# CITY OF ALBUQUERQUE

February 3, 2012

**Re: Garfield Apartments, 501 Girard Blvd SE, Traffic Circulation Layout  
Engineer's Stamp dated 01-09-12 (K16-D079)**

Grading & Drainage
Plan

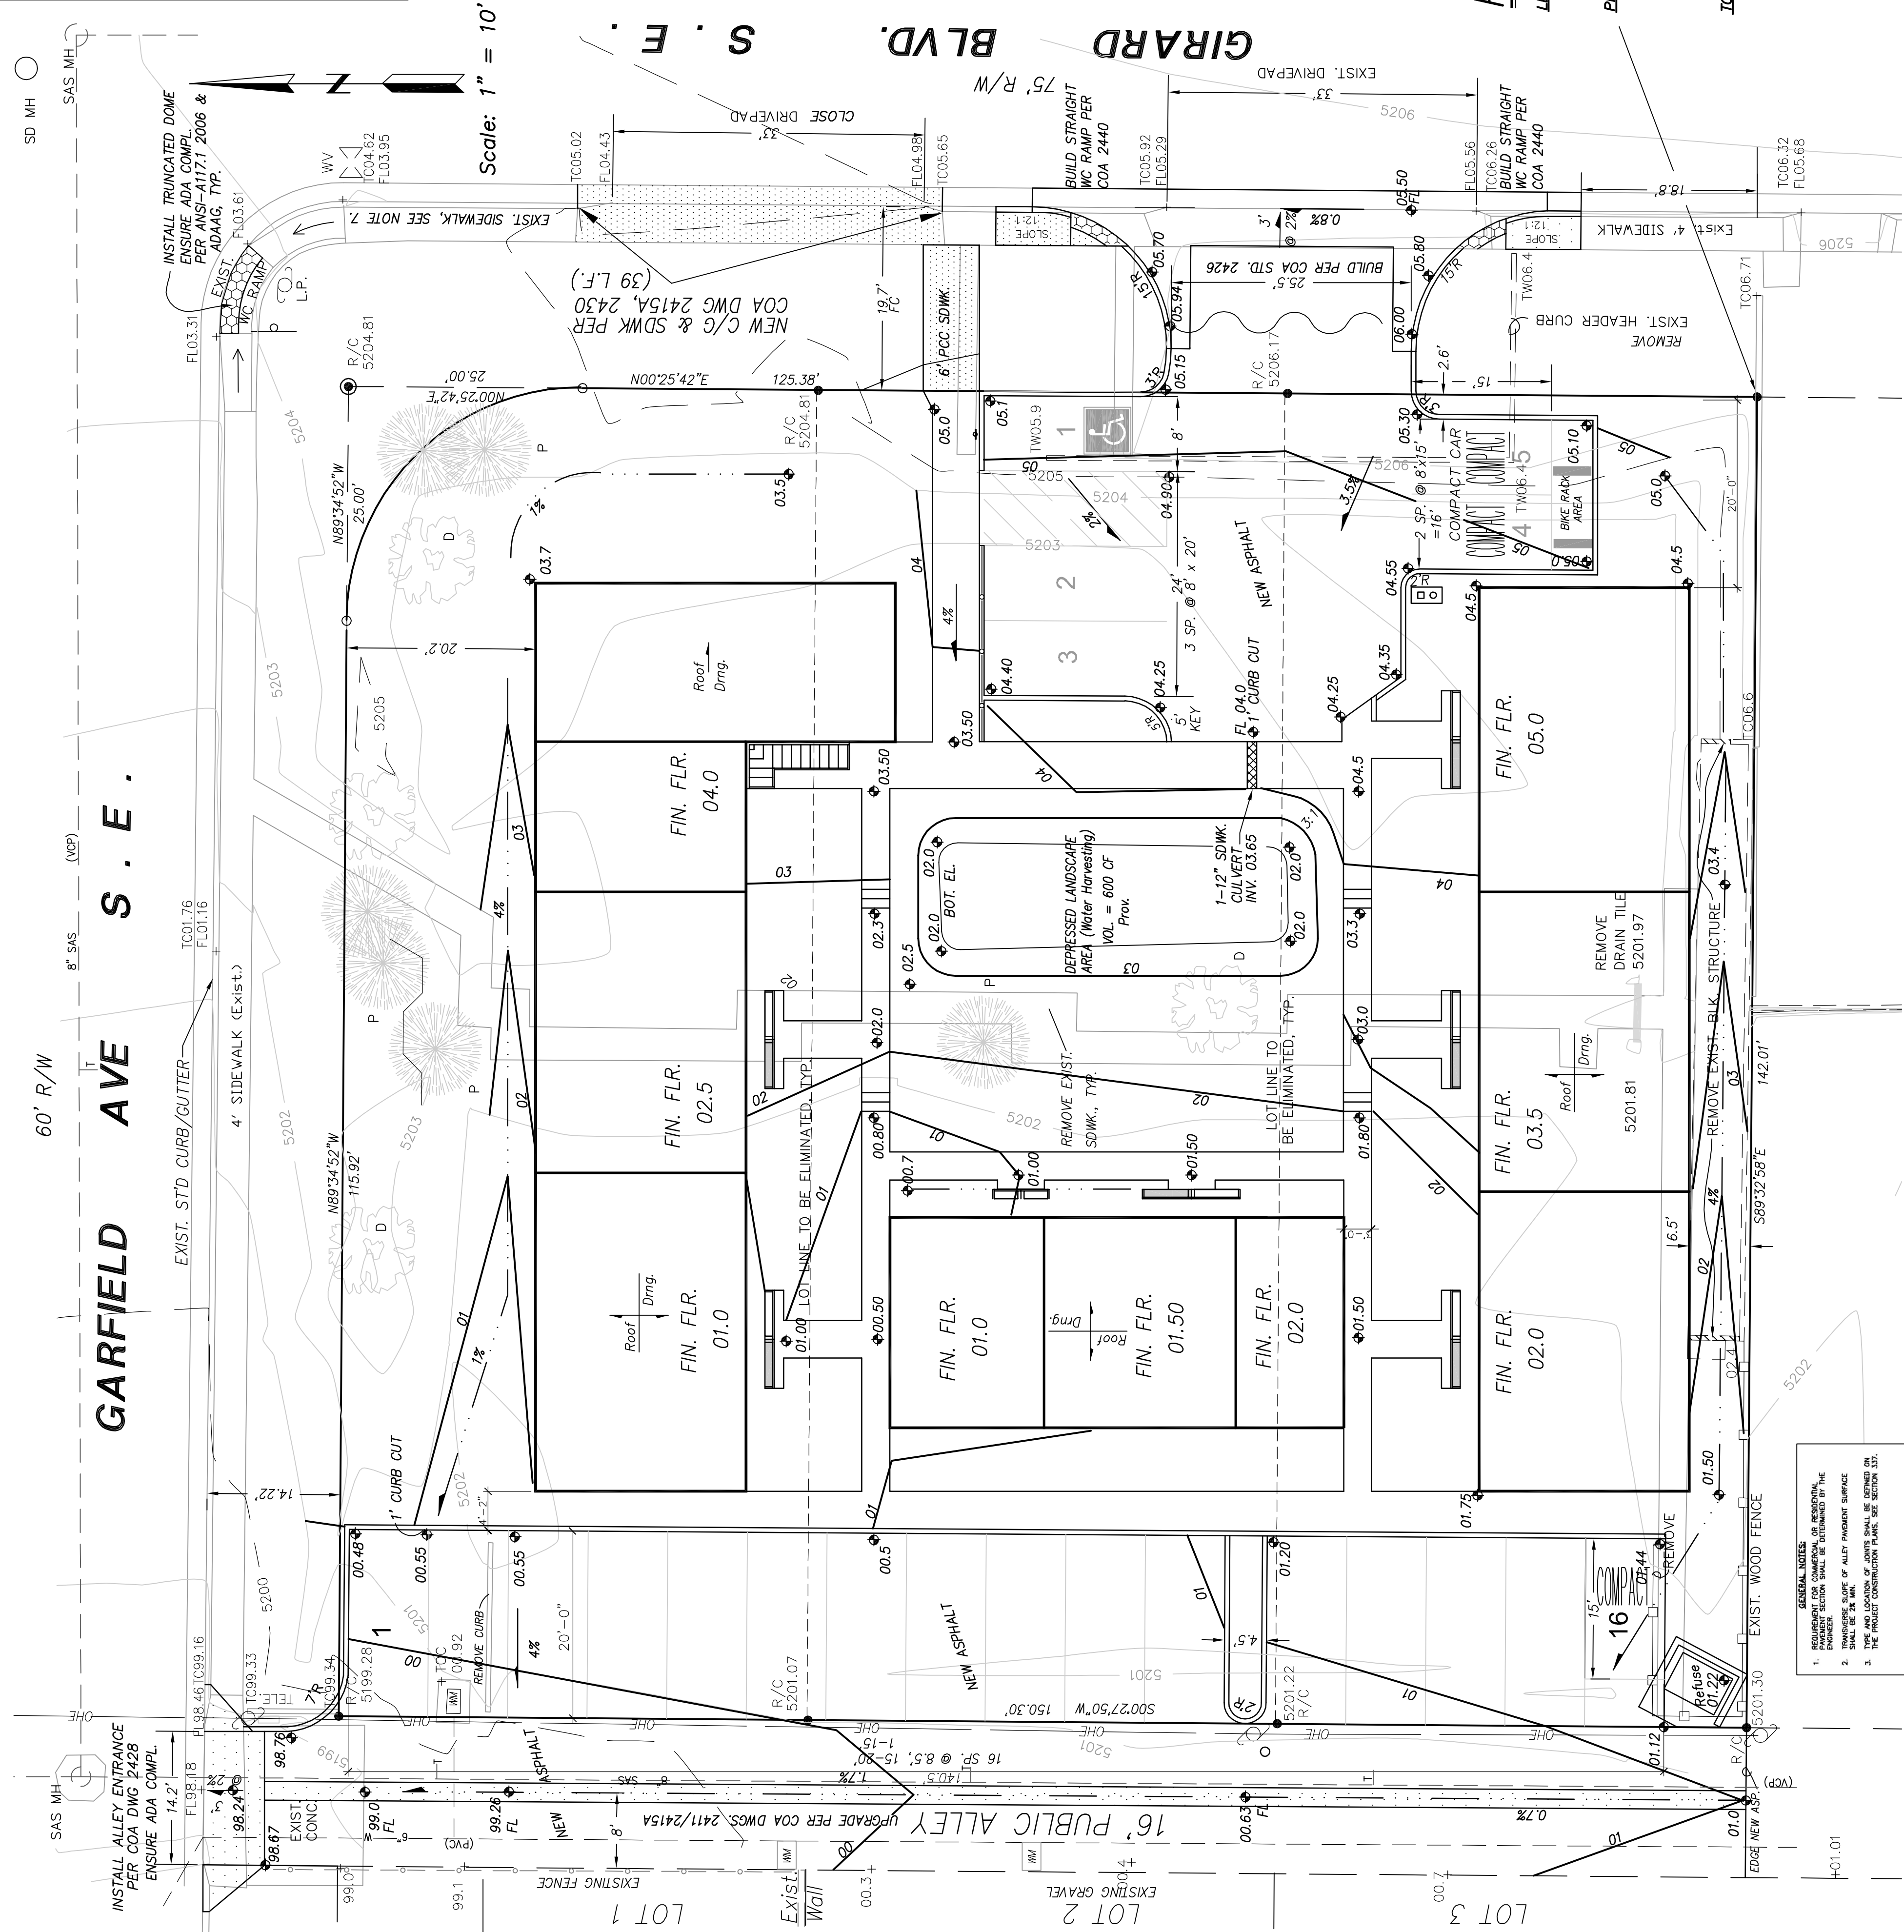
1. Clearly indicate which items are to be built under City work order.
2. Show the internal ramps and provide details.
3. All ramps within City right of way must have truncated domes.
4. Label the compact parking spaces by placing the words "compact" on the pavement of each space.
5. The placement of the refuse container appears to interfere with the parking stall. Please revise. Provide a copy of approval from Solid Waste.
6. Provide a build note for the revised entrance off of Girard. Refer to the specific City standard.
7. There is no City standard for truncated domes; please revise the note at the corner of Garfield and Girard.
